# CITY OF ALBUQUERQUE

**RE: 8401 Glendale Ave. NE**  
**Grading and Drainage Plans**  
**Engineer's Stamp Date: 7/8/25**  
**Hydrology File: B20D070**  
**Case # HYDR-2025-00243**

C1.0

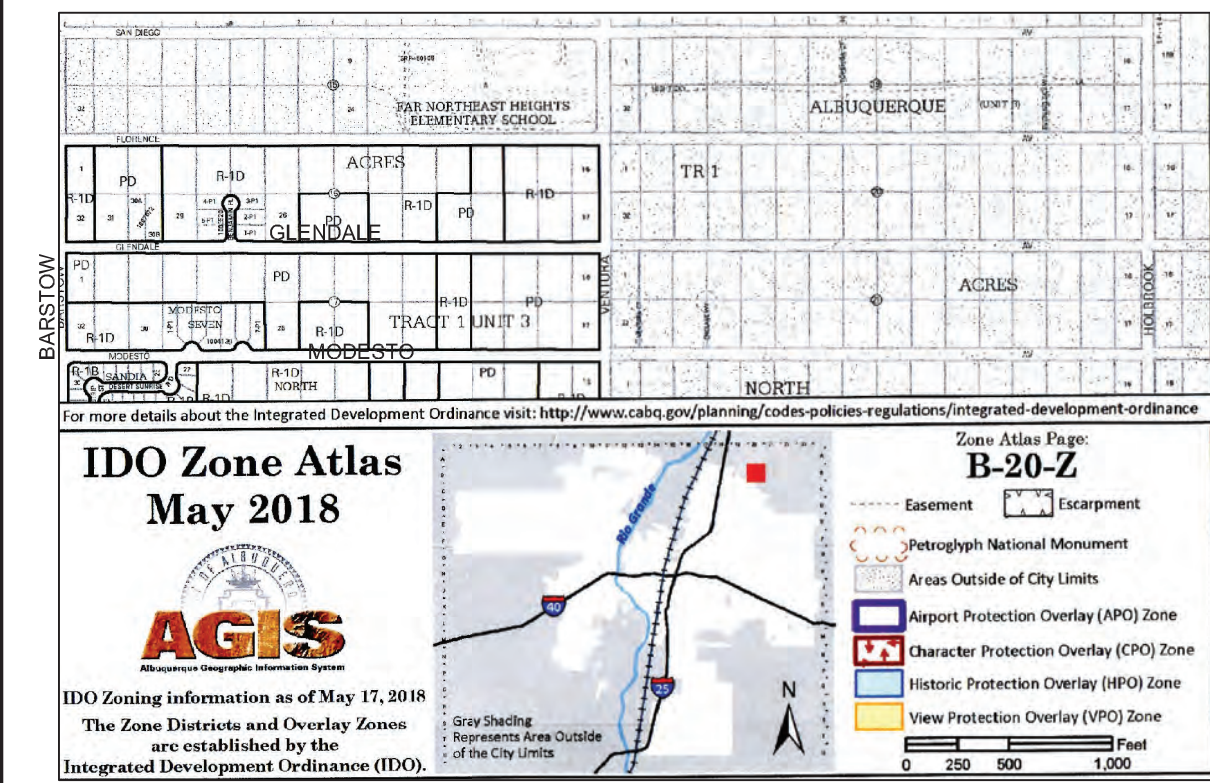
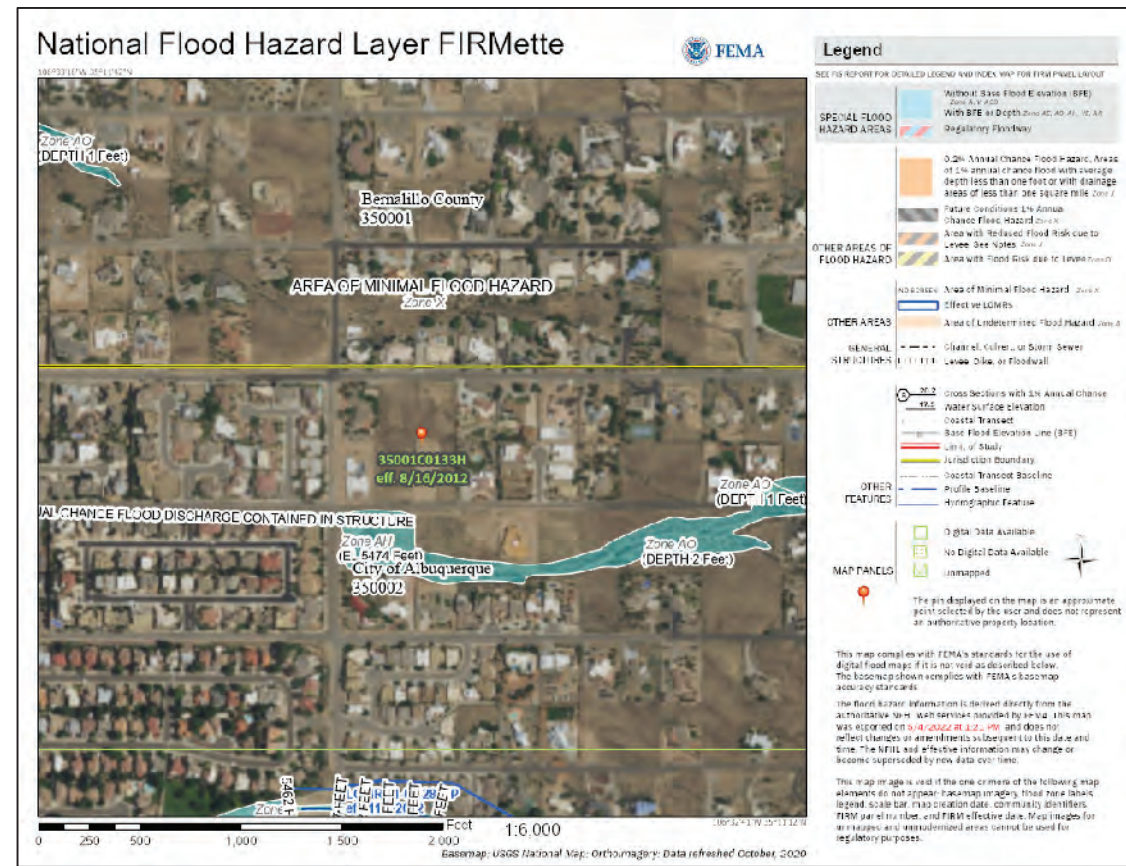
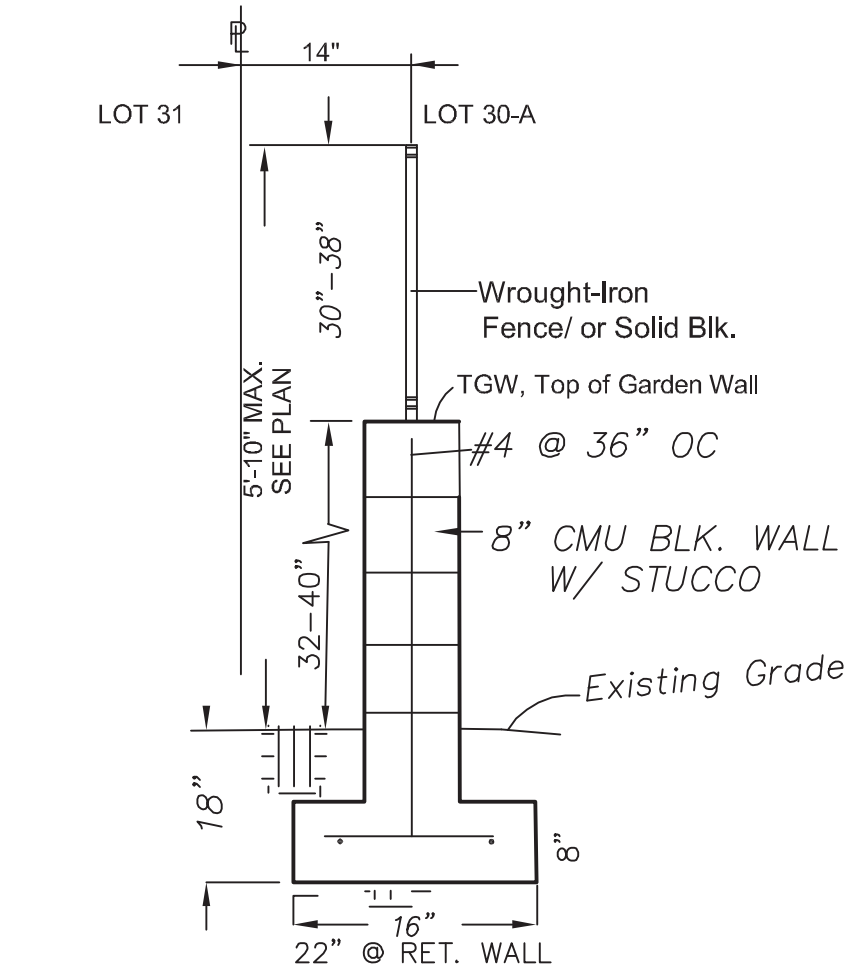
1. Please update the existing conditions narrative. The site is not presently undeveloped. It appears that this plan is for a shed at the north portion of the site but the narrative states that it is for a proposed 3600 sf residence.
2. Please update the SWQV calculations to include the new addition.
3. Remove all redlines shown on the plan.
4. Remove the Engineering Certification from the previous project.
5. Remove the extra date by the PE Stamp. Only 1 stamp date should be shown on the new plan.
